**Application Number:** 13DRB-70724, Minor - Preliminary/ Final Plat Approval

**Application Number:** 13DRB-70726, Epc Approved Sdp For Build Permit

☐ **Project #1005280 McMahon Marketplace**

☐ **13DRB-70726 EPC Approved SDP For Building Permit**

PROJECT # 1005280  
 10-30-13  
 13-70724(P&F)

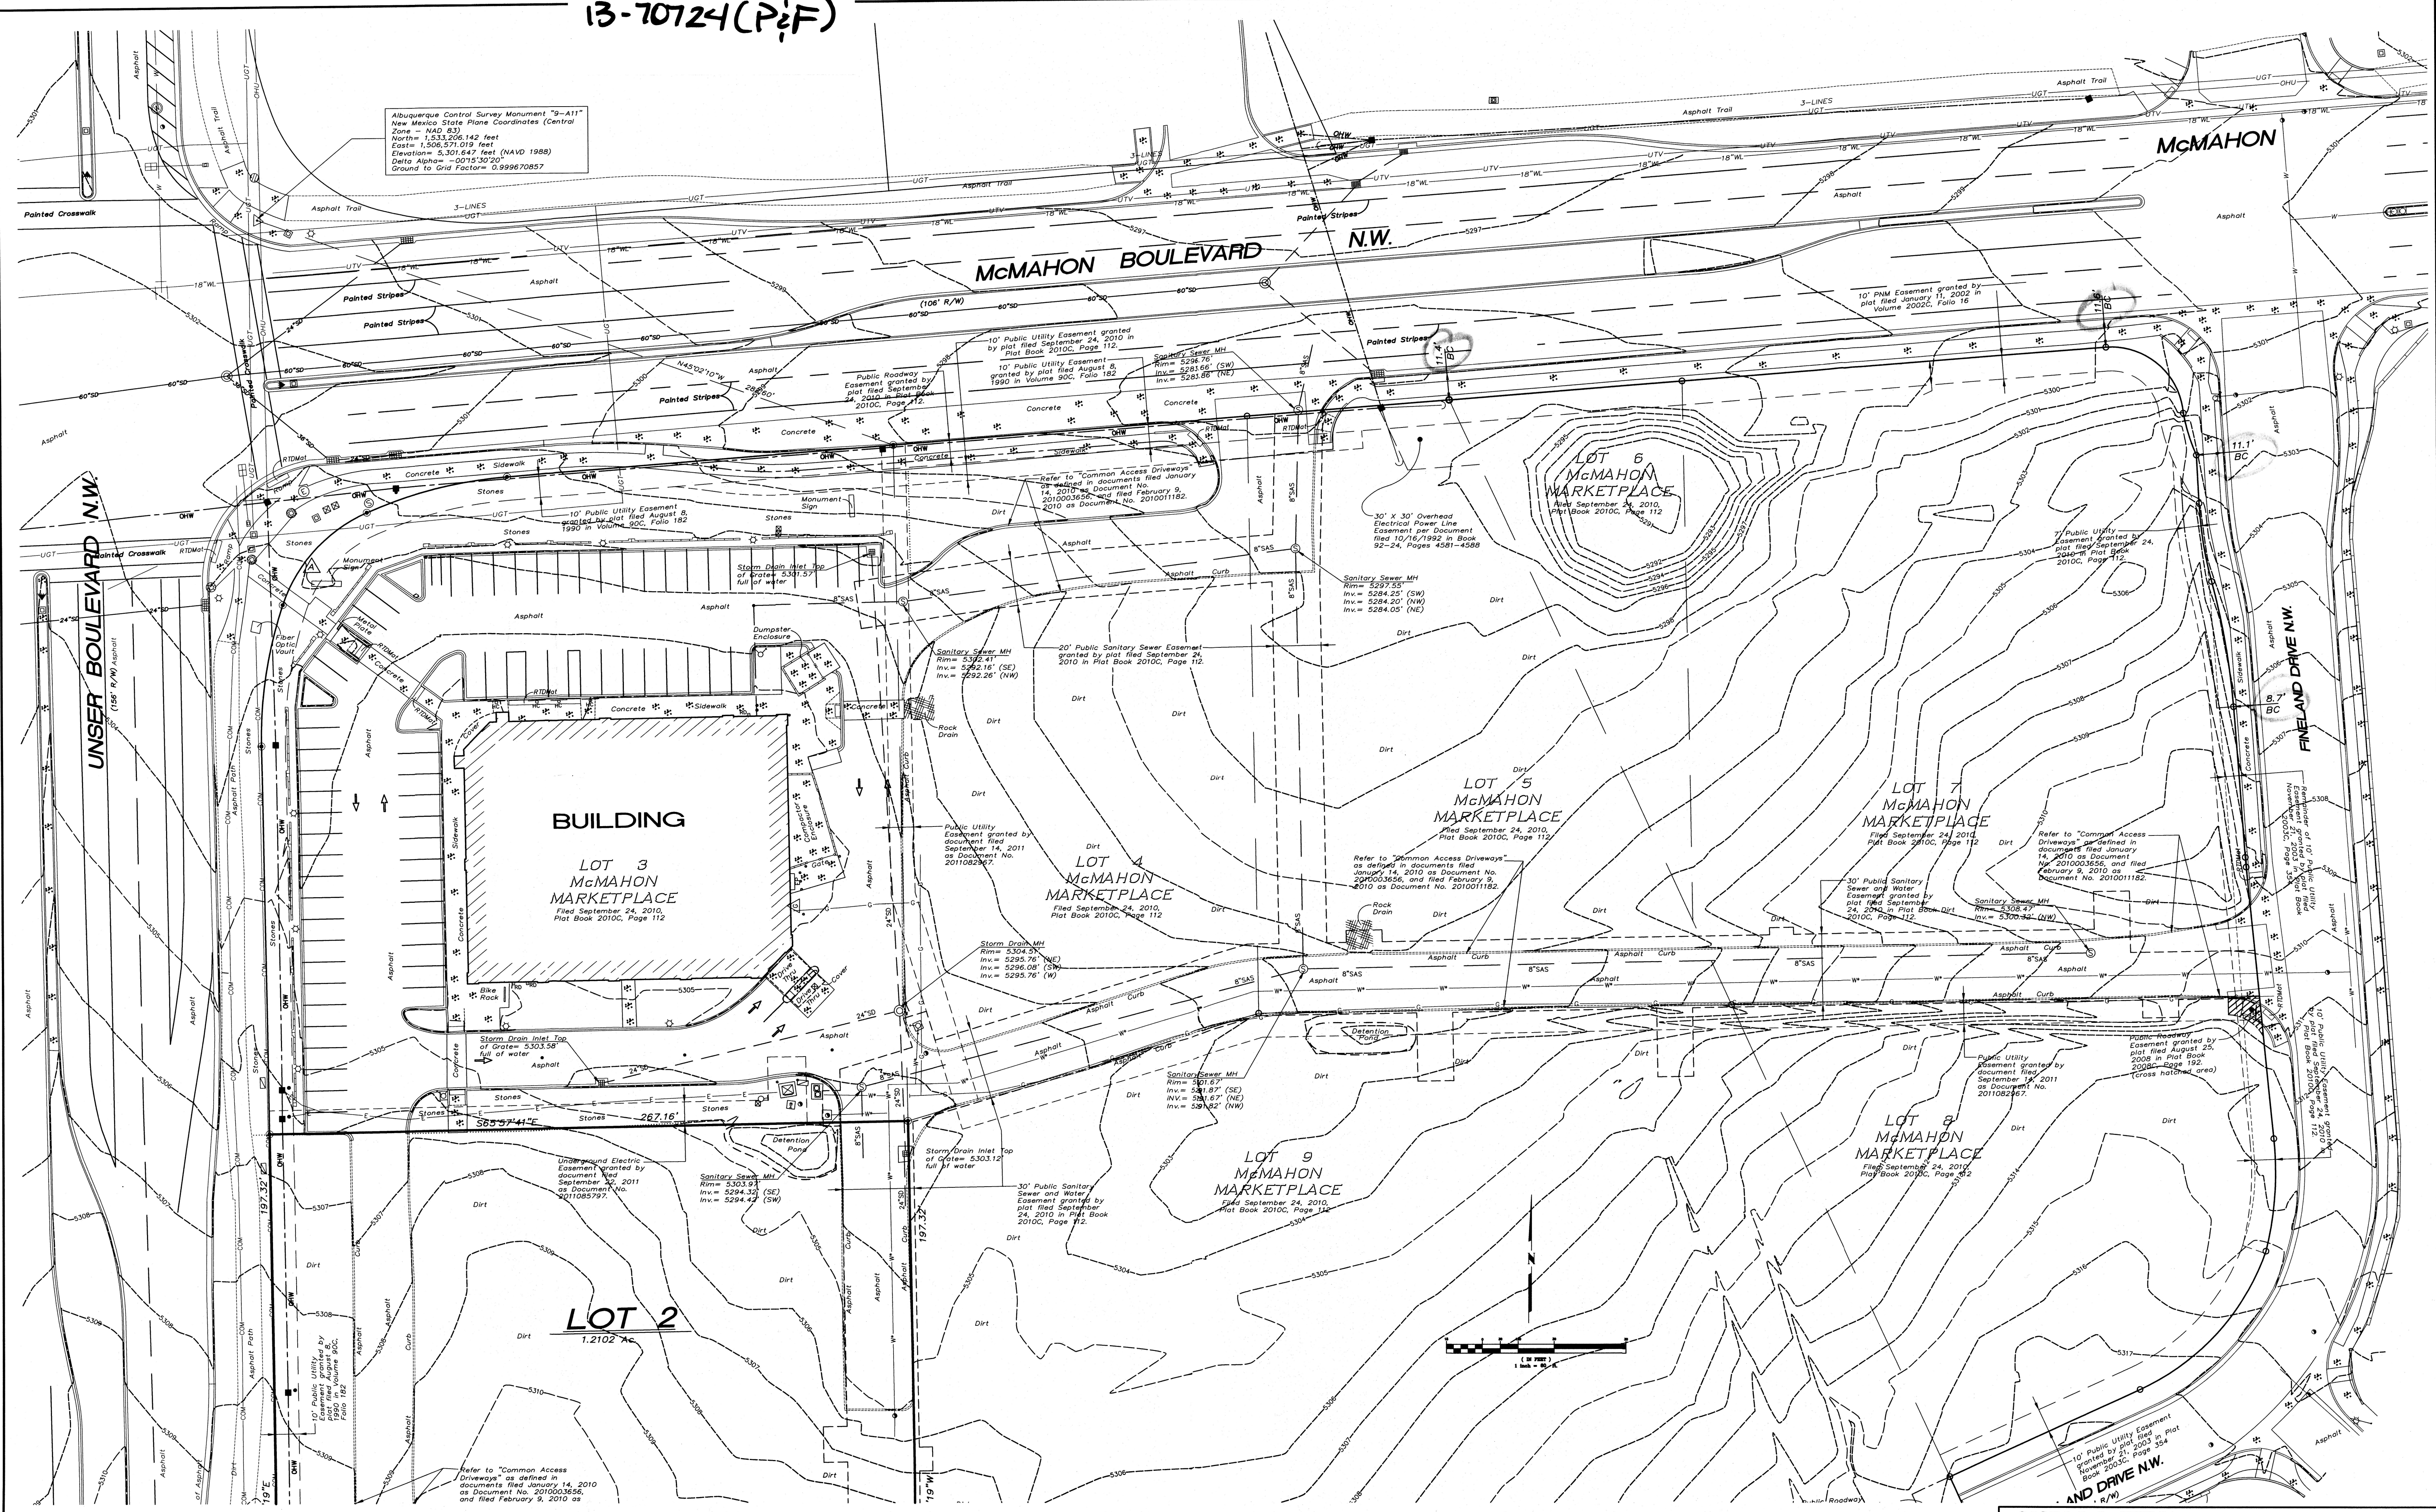
**See comments above requiring note on plat and letter from owner regarding Irrigation in City ROW.**

LANDSCAPE PLAN - LOT 7

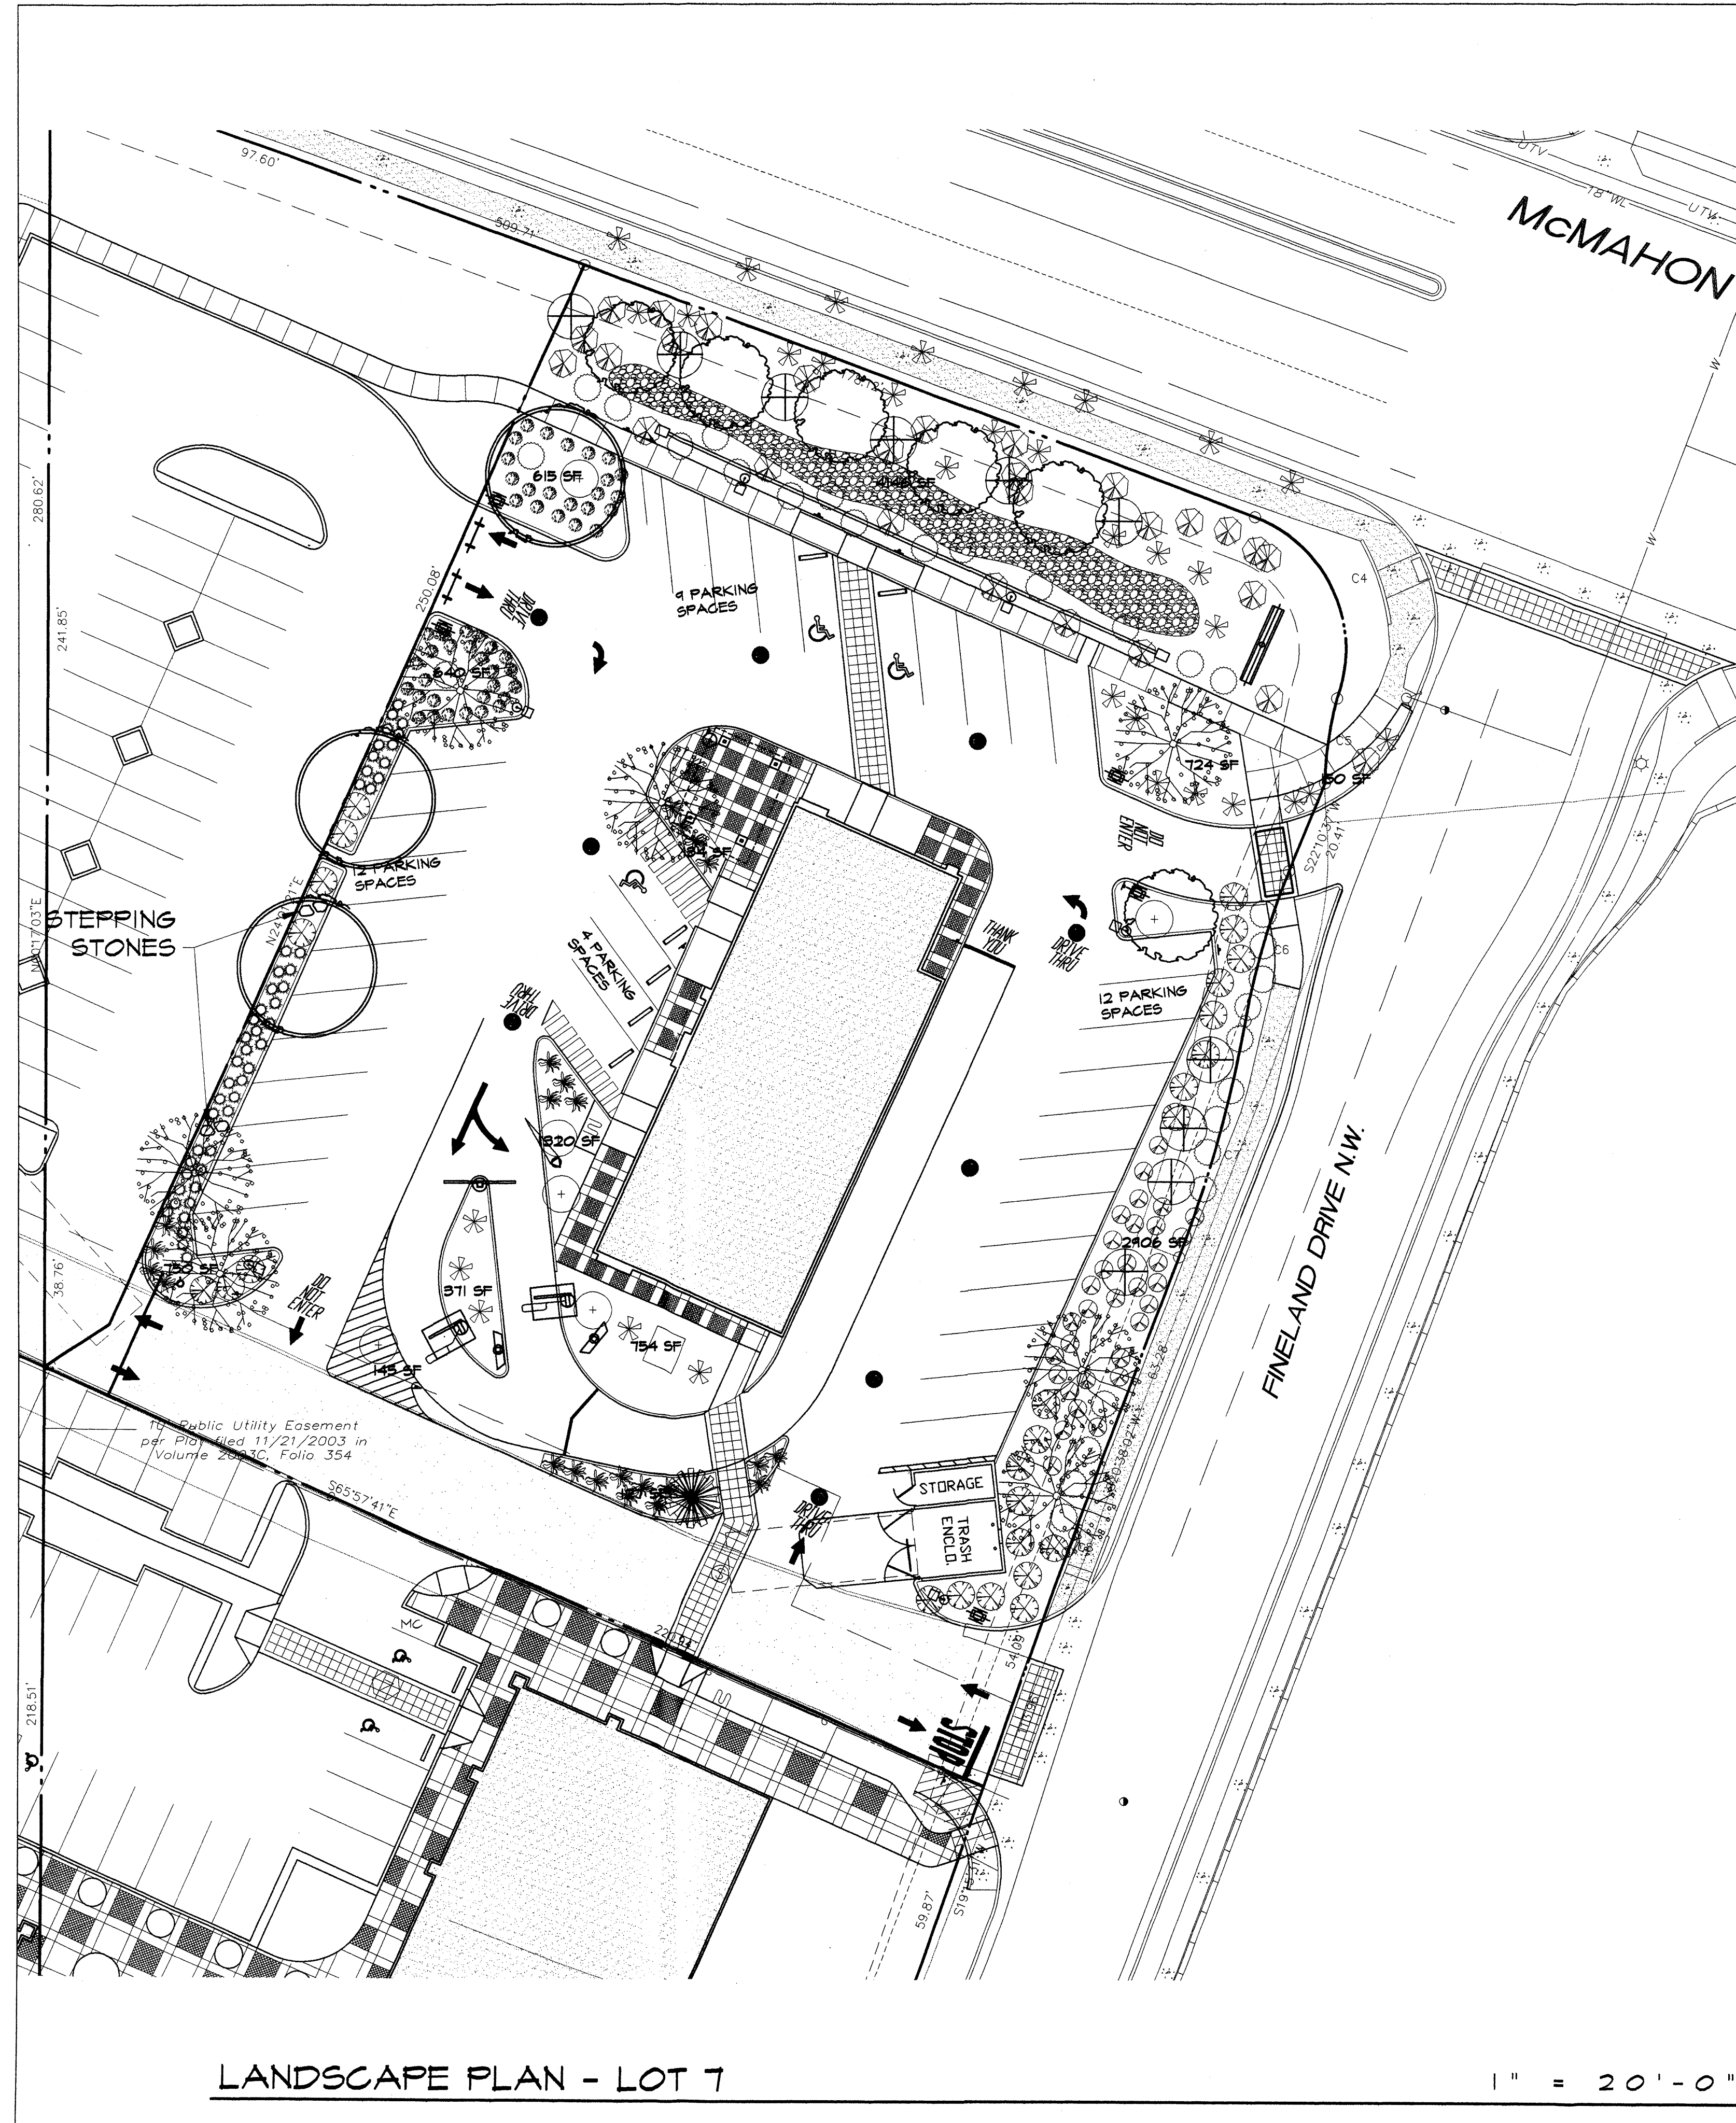
**Need Note on Landscape Plan and letter from owner stating that Irrigation for landscaping in City ROW will be provided from connection to irrigation system for landscaping on subject property.**
